OXFORDSHIRE COUNTY COUNCIL'S RESPONSE TO CONSULTATION ON THE FOLLOWING DEVELOPMENT PROPOSAL

Application no: 21/02893/REM

Proposal: Approval of reserved matters pursuant to condition 1 of planning permission 18/01894/OUT for details of layout, appearance, scale, landscaping, access and parking for 25 dwellings

Location: North Of Shortlands And South Of High Rock, Hook Norton Road, Sibford Ferris

Design Proposal | Site Access and General Arrangement Plan

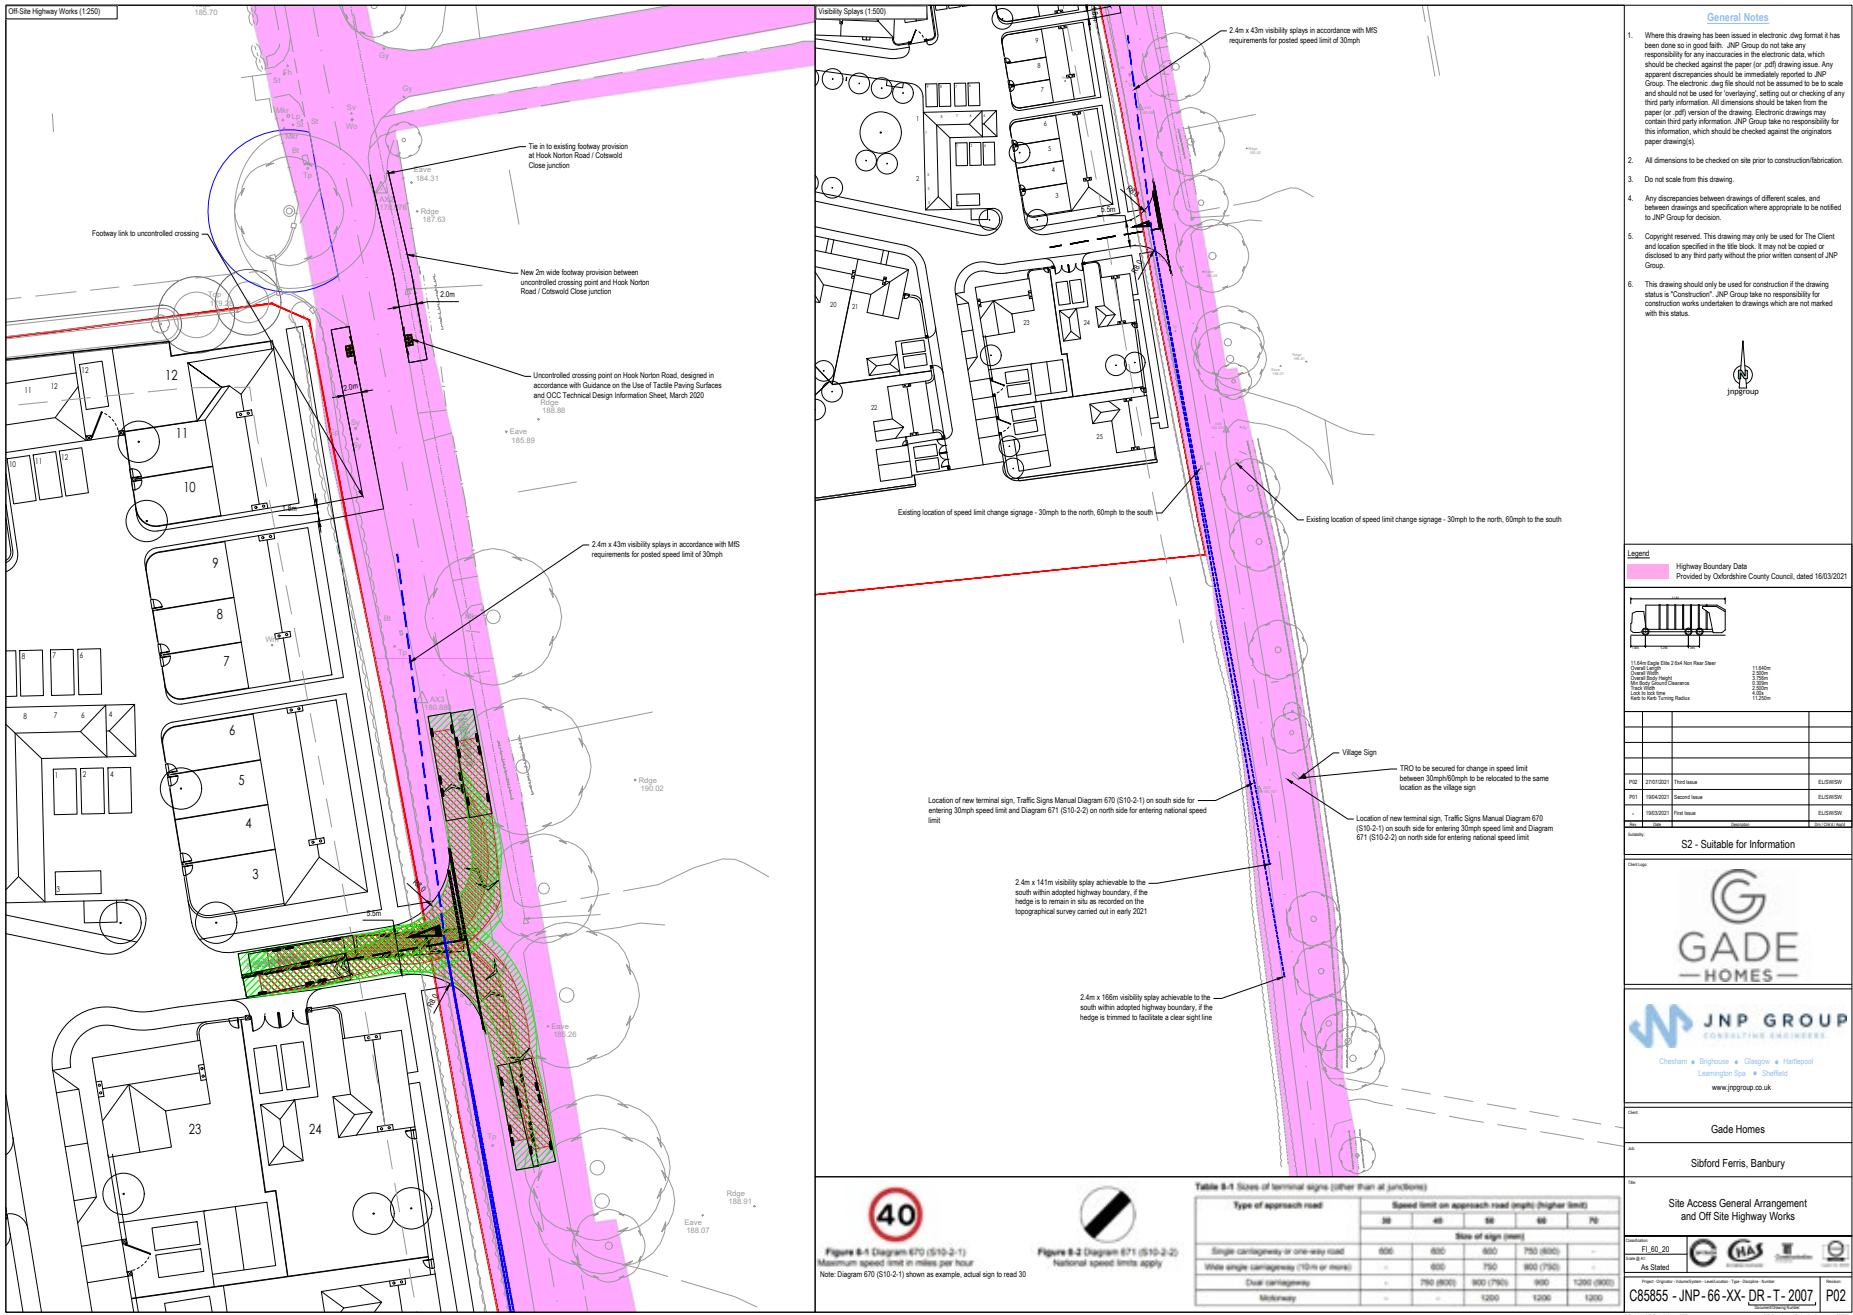
Road 5 now creates a circuit with Road 4, so that the Refuse Collection Vehicle may be able to continue right the way around and avoid the need to execute a turning manoeuvre. An updated Swept Path Analysis is necessary to demonstrate that this is possible.

The visibility splay across the south-west corner of the central LAP area is obstructed by two trees and other planting, so this is unacceptable. All visibility splays must be clear from obstruction and if the roads are proposed for adoption then visibility is required to be dedicated too.

All footways must be a consistent 2.0m width. Where there are openings to driveways and parking areas, these should be footway crossovers rather than bellmouth accesses.

As the site is on a slope, the applicant must be able to demonstrate, by providing long sections, that the carriageway and footway gradients are DDA compliant, i.e. maximum 1:20.
